CITY OF ALBUQUERQUE

September 10, 2013

**Re: Mix-Use Development, 4322 4th St. NW
Grading and Drainage Plan
Engineer's Stamp Dated 8-12-13 (G14/D071)**

A PROPOSED PLAN FOR A MIXED-USE DEVELOPMENT (4322 FOURTH STREET N.W.) ALBUQUERQUE, NEW MEXICO JULY, 2013

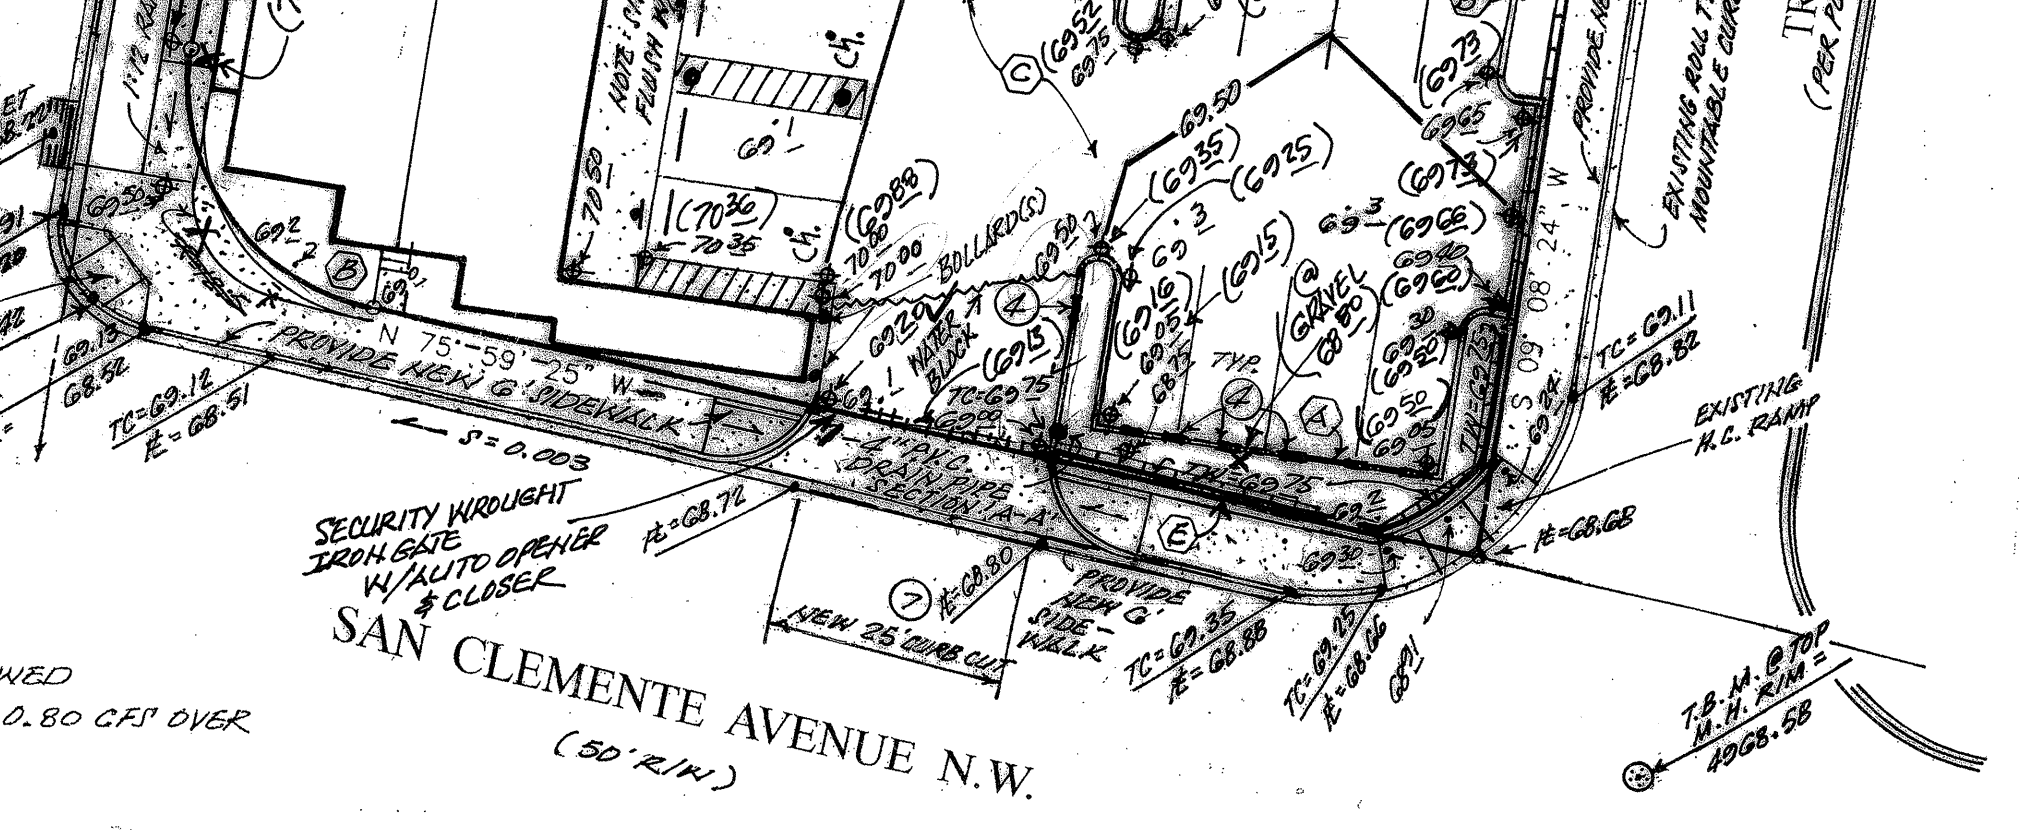
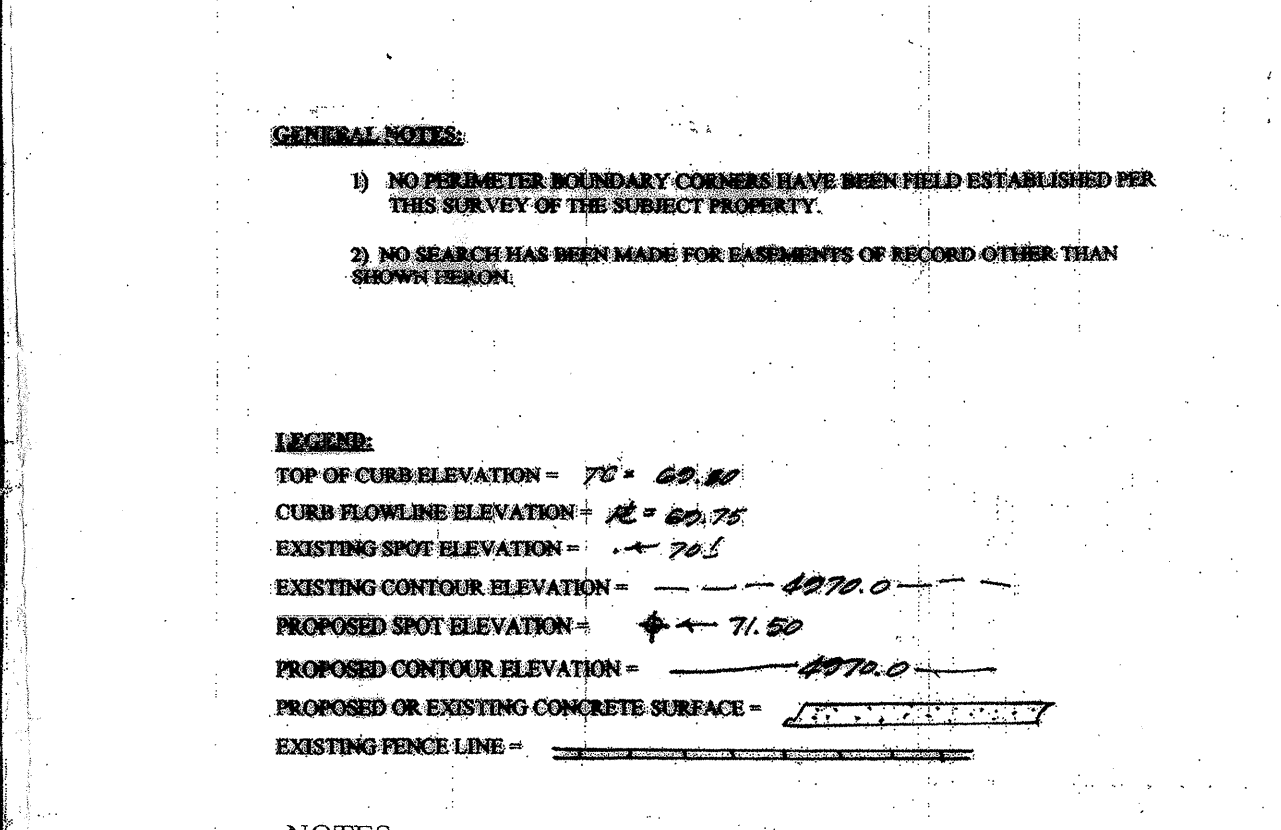
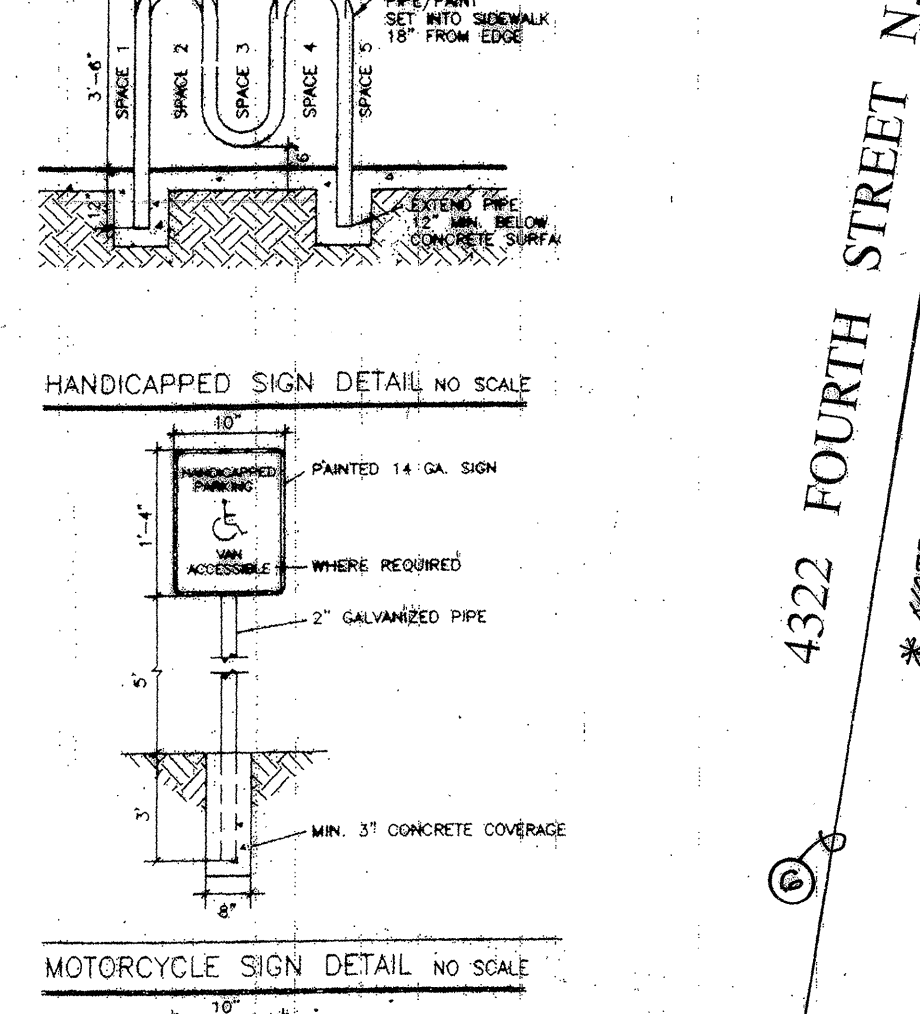
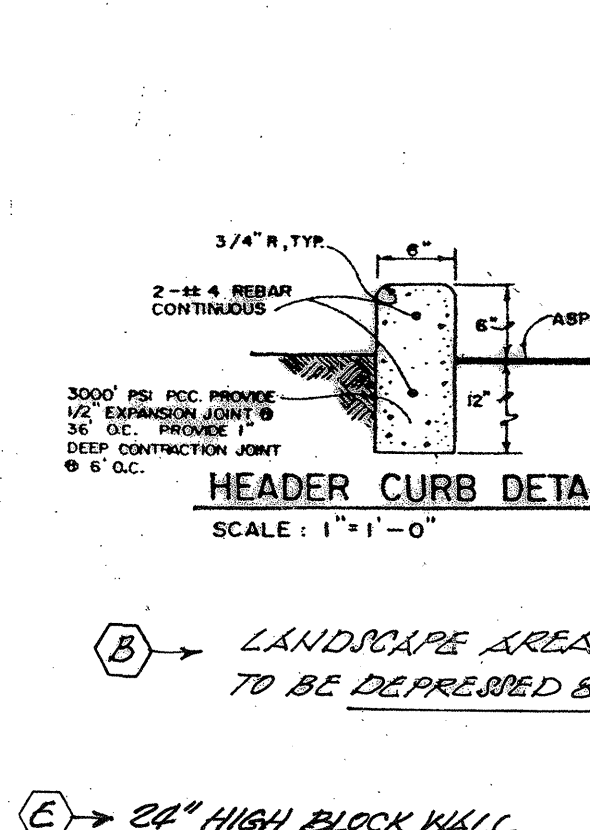
- Show existing topography/spot elevations.
- The site should drain to 4th St. at an allowable discharge rate of 2.75 cfs/ac.
- Remove the proposed wall within the turn around easement. The turn around area should be constructed.

- There are proposed steps within the City ROW. An encroachment agreement is required for the steps.
- Portion of the HC ramp is within private property. Easement will be required.

- Provide roof flow directions. Runoff can not flow over public sidewalks.
- Is there access easement on Tract J for the use of this project? Please provide plat or documentation which shows access easement across Tract J.

- Is there adequate landscaping area shown on this plan? Please confirm with zoning prior to resubmittal of the grading and drainage plan. Depress all landscaping areas.

- Will there be a restaurant on this site? If so, the trash enclosure area must drain to an oil waster separator and then to the sanitary sewer system. Provide detail elevations for the enclosure.
